**19955 Wigwam Road, PPR-24-7**

Please accept the following comments from El Paso County Public Health (EPCPH) regarding the project referenced above:

Mike McCarthy  
El Paso County Public Health  
719-332-5771  
[mikemccarthy@elpasoco.com](mailto:mikemccarthy@elpasoco.com)  
10May2024

GRADING & EROSION CONTROL PLAN
POND PLAN

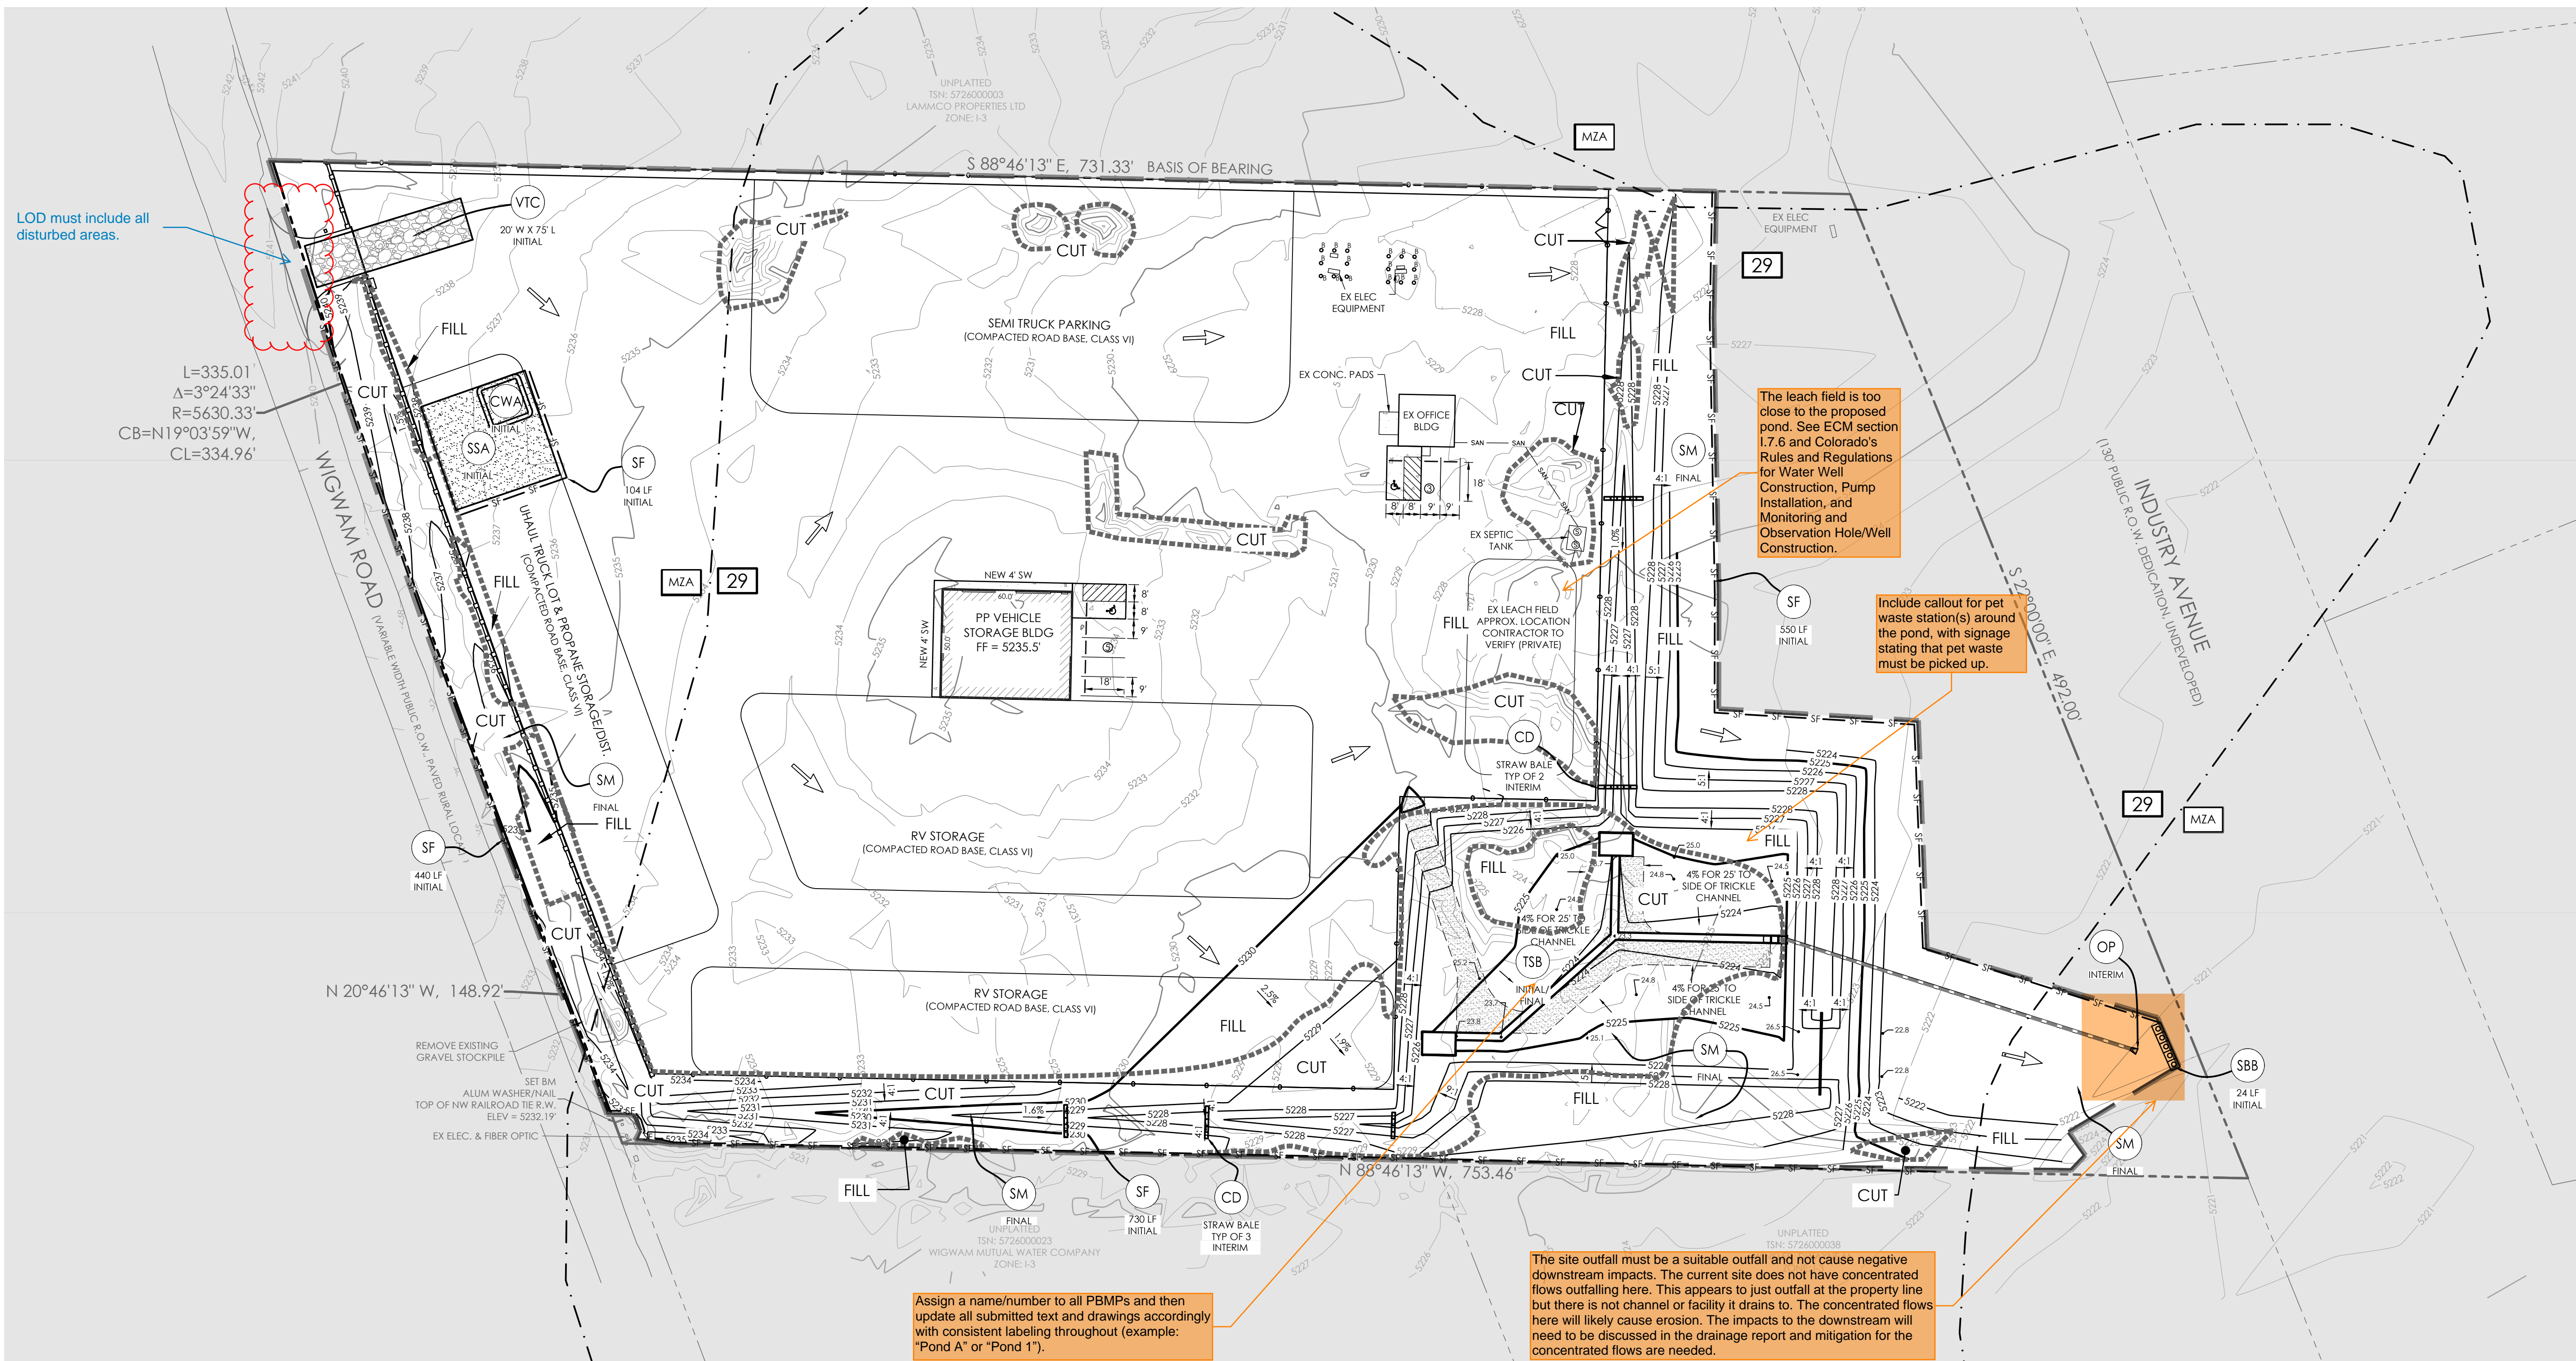
- The water quality basin must have mosquito control responsibilities included in the maintenance plan as a part of the construction design and maintenance plan to help control mosquito breeding habitat and minimize the potential for West Nile Virus.
